Application No: A/33/26/HH
Site Address: 29 Mill Road Avenue Angmering BN16 4HR
Description of works: Single storey front and rear extension, hip to gable loft conversion with front and rear dormers, new car port and alterations to fenestration.

Objections to planning application A/33/26/HH - 29, Mill Road Avenue

Drawing Name:
Proposed Elevations

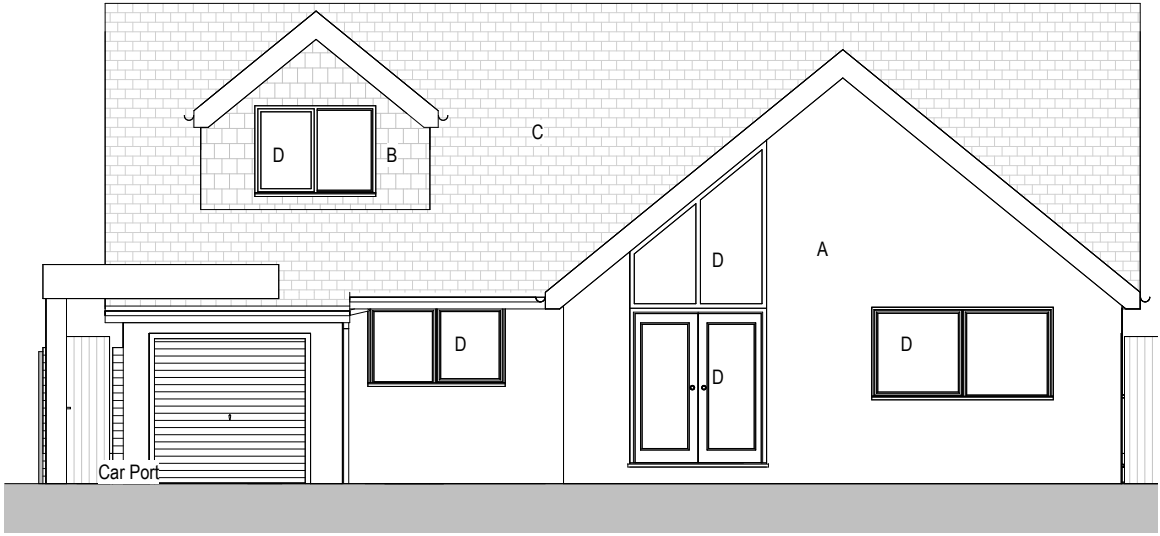
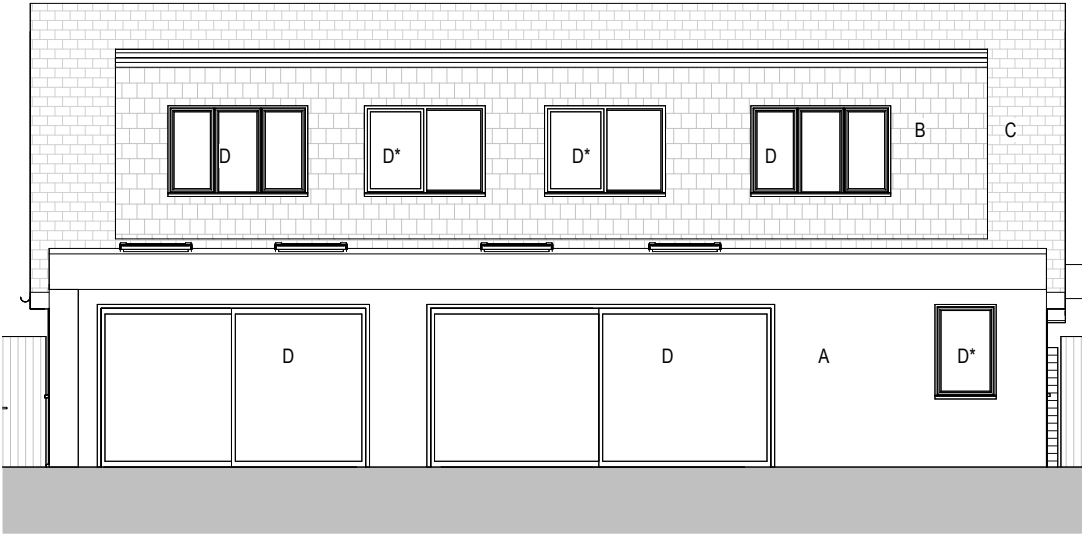
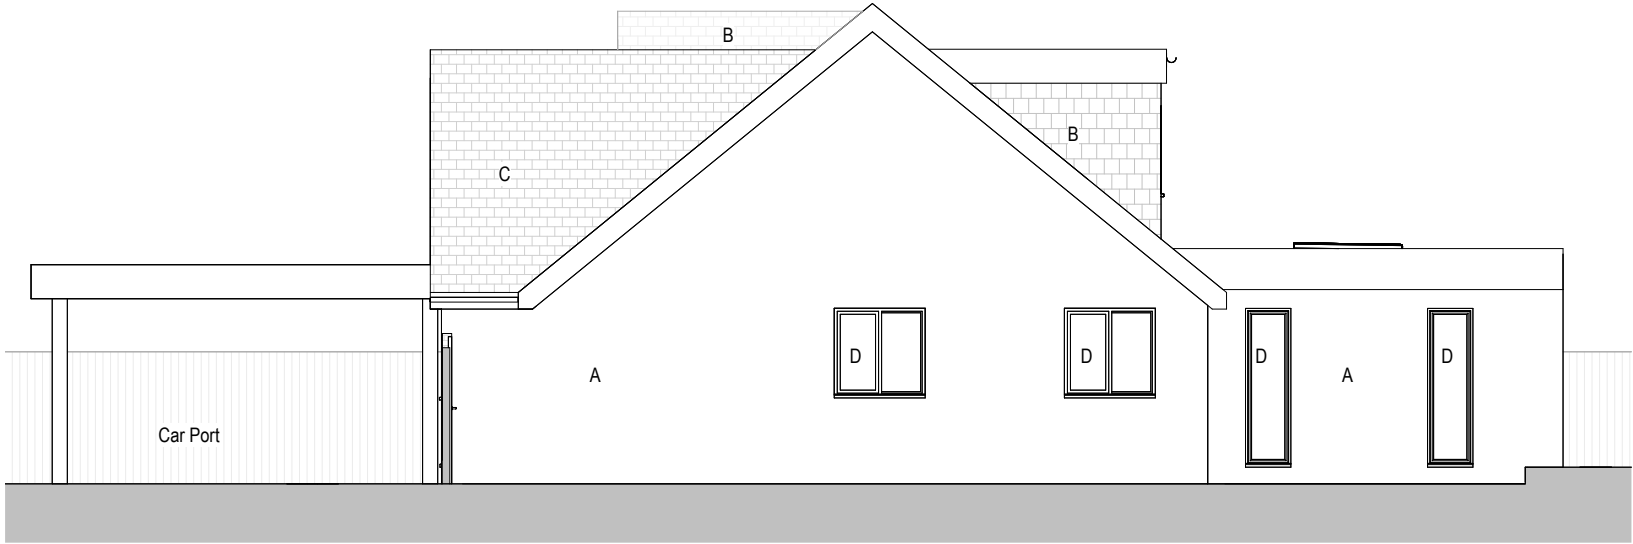
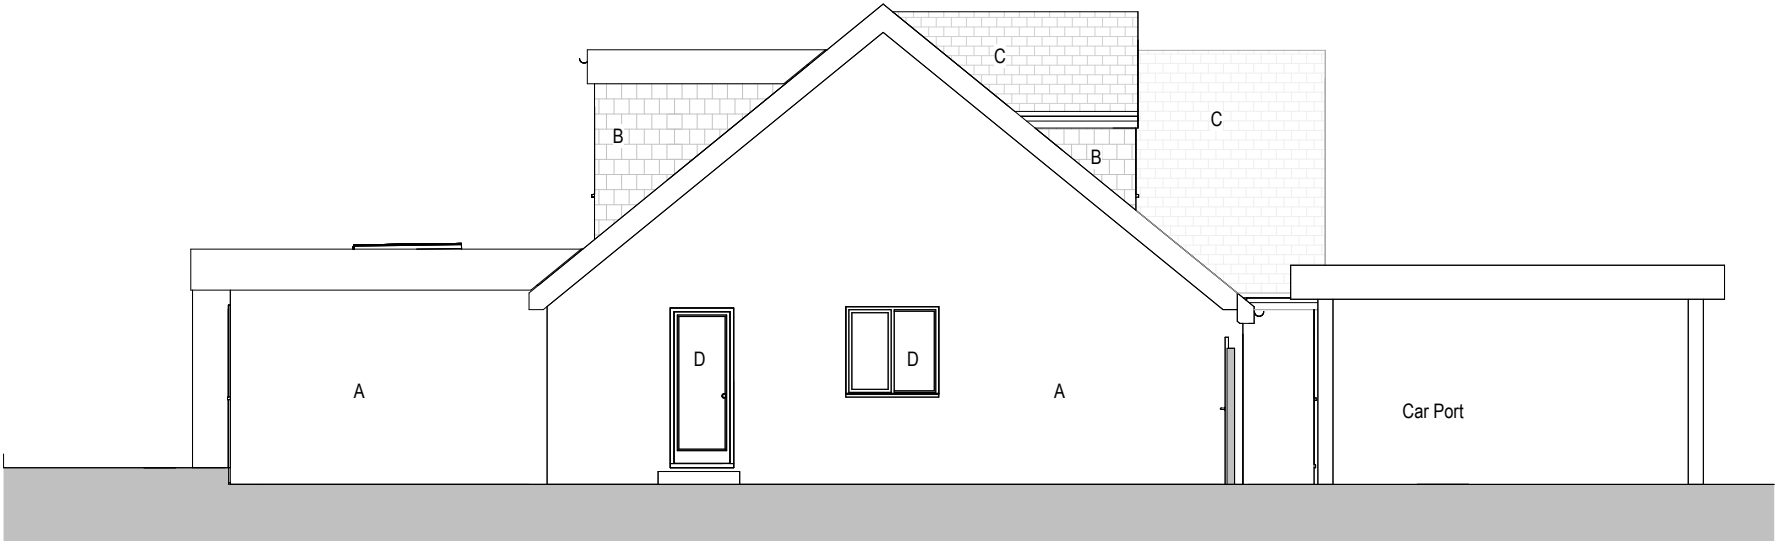
- 1) The proposed front dormer window would over look the bedrooms of my property being directly opposite. One of the main reasons for my wife and I buying 50 Mill Road Avenue was the privacy that it offered by not being directly overlooked. This would now happen with the first floor window, providing a higher view point than the existing bungalow. Also the overall change to the front of the property is not in keeping with the character of the road.

Drawing Name:
Proposed Block Plan

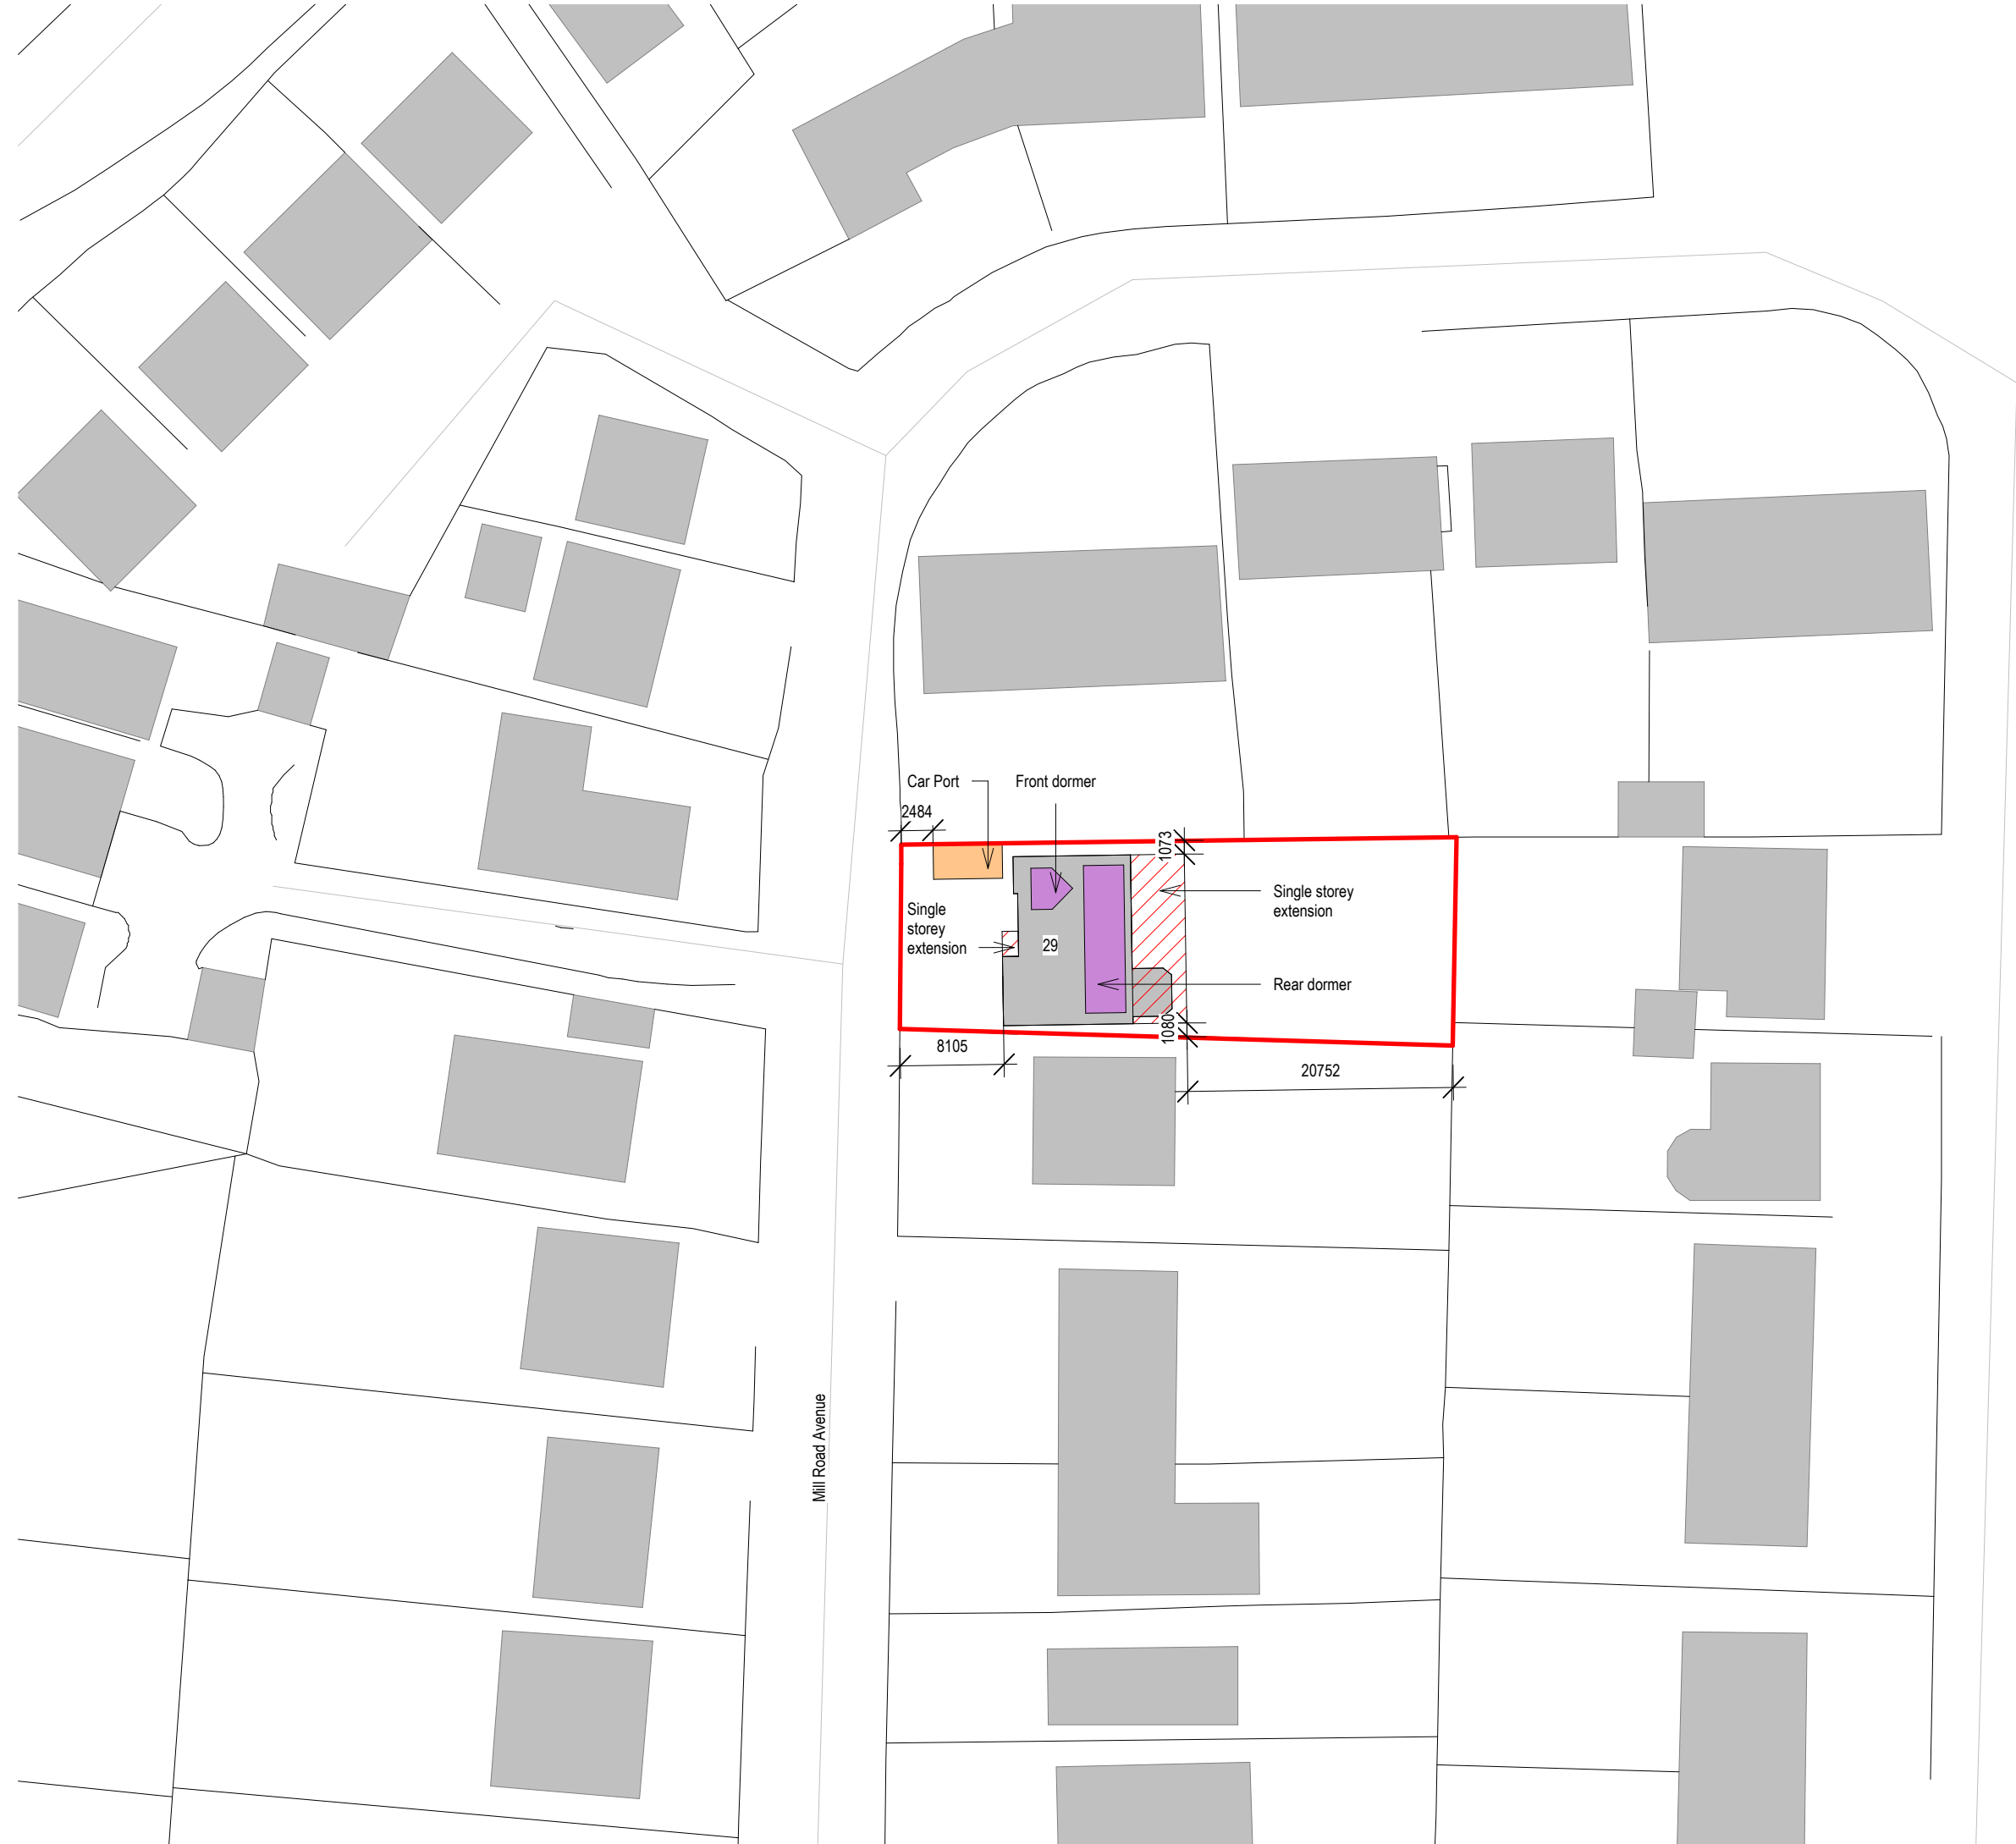
- 2) The proposed Car Port, is not only out of character with the rest of the road but is also well outside the building line for not only No.29 but the rest of the properties on that side of the road. Also No.29 does have an existing garage.
